MEMORANDUM

TO: Nell Donaldson, Planner
FROM: David Senus, P.E.
DATE: May 29, 2013
RE: Pomeroy Street Construction, Level II Site Plan Application

Woodard & Curran has reviewed the Response to Comments letter and attachments for the Level II Final Site Plan Application for the Pomeroy Street extension located off of Bancroft Street in Portland, Maine. The parcel was previously approved for a Site Plan and Conditional Use Permit in August of 2005 by the City for a single family residence with attached synagogue; however, these permits have since expired. The current amended project consists of developing a single family home (Level I) and construction of approximately 200 linear feet of Pomeroy Street (Level II).

CURTAIN DRAIN  
N.T.S.

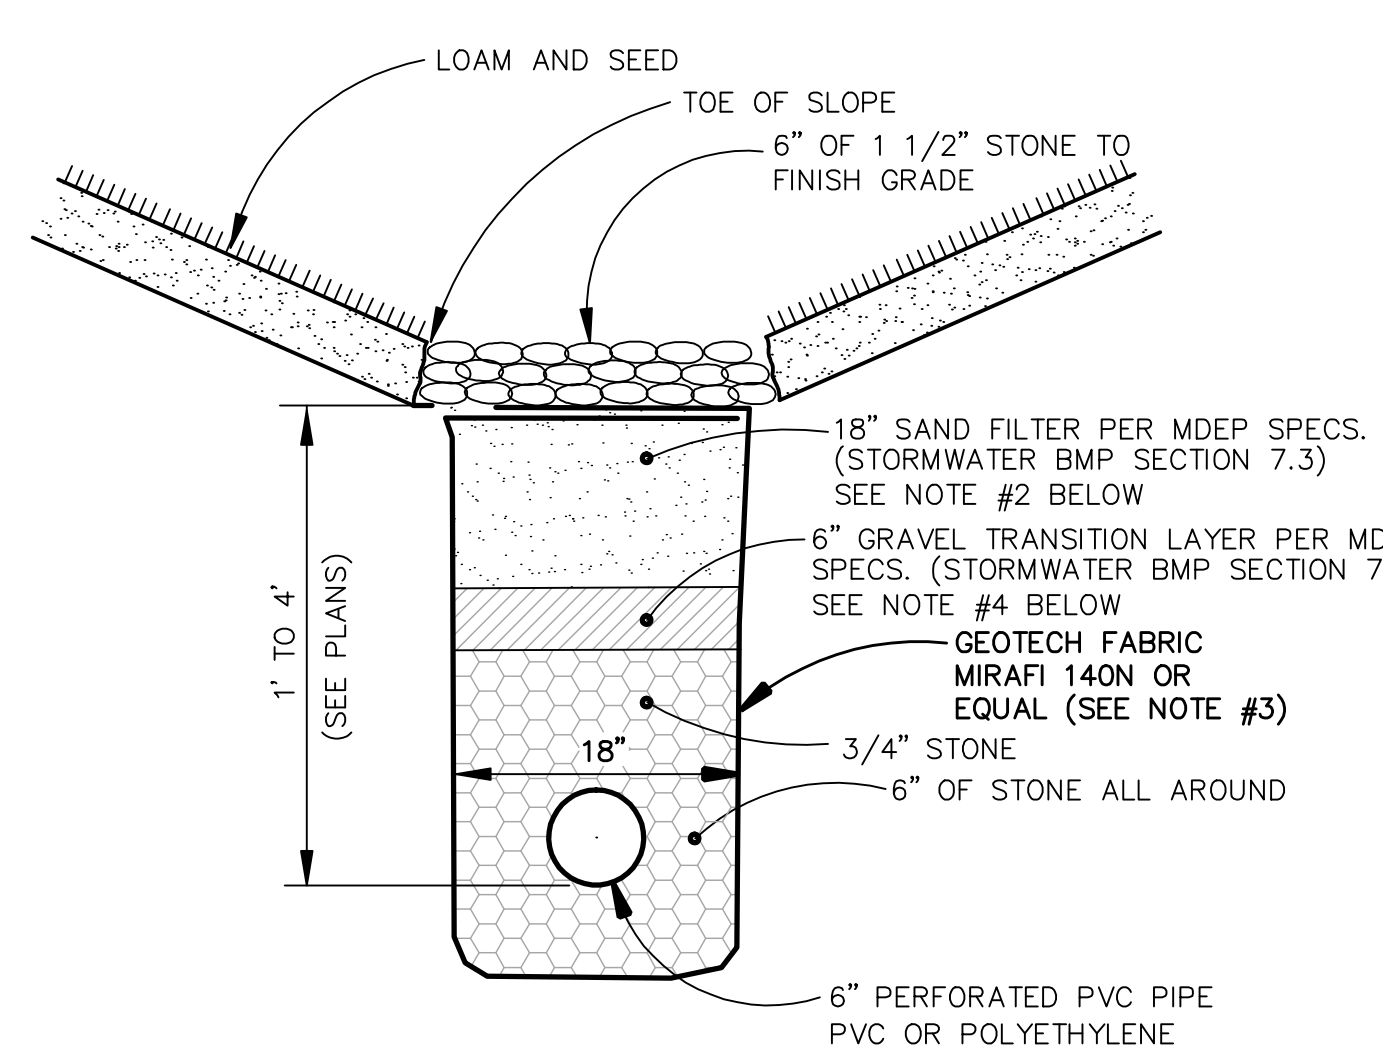
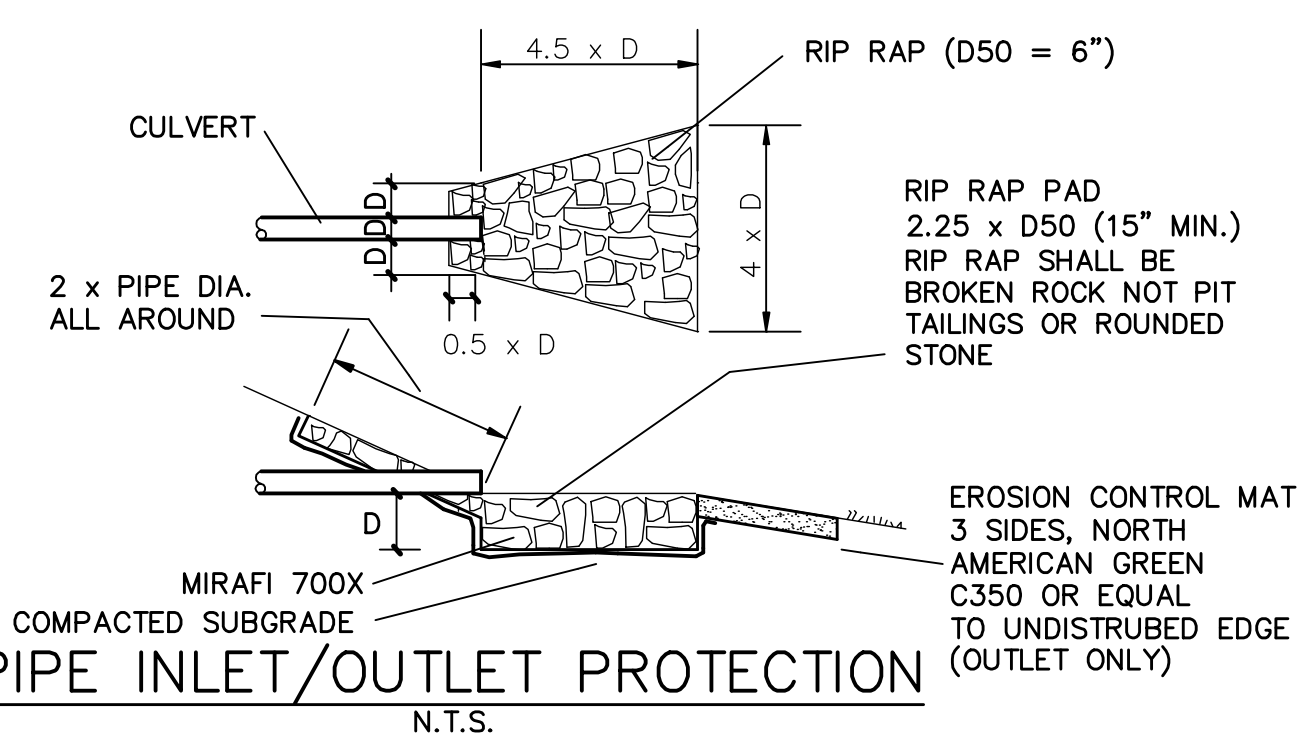
- 1) The Curtain Drain detail on C-5 has been revised to include an 18" sand filter layer. The detail states that the sand filter layer shall be "Per City of Portland Specifications". The City of Portland does not provide specifications for a sand filter; however, MaineDEP does define a sand filter material in their Maine Stormwater Best Management Practices Manual, Volume III. BMP Technical Design Manual Chapter 7.3 - Underdrained Subsurface Sand Filter BMP (note that this Chapter describes a different type of BMP than in the Applicant's proposal, but the filter layer can be considered applicable to this project).

In addition, the Applicant should avoid using filter fabric across the filter system due to potential clogging and should include a gravel transition layer between the sand filter and the crushed stone bedding material, refer to 7.3.3 Pipe Bedding and Transition Zone.
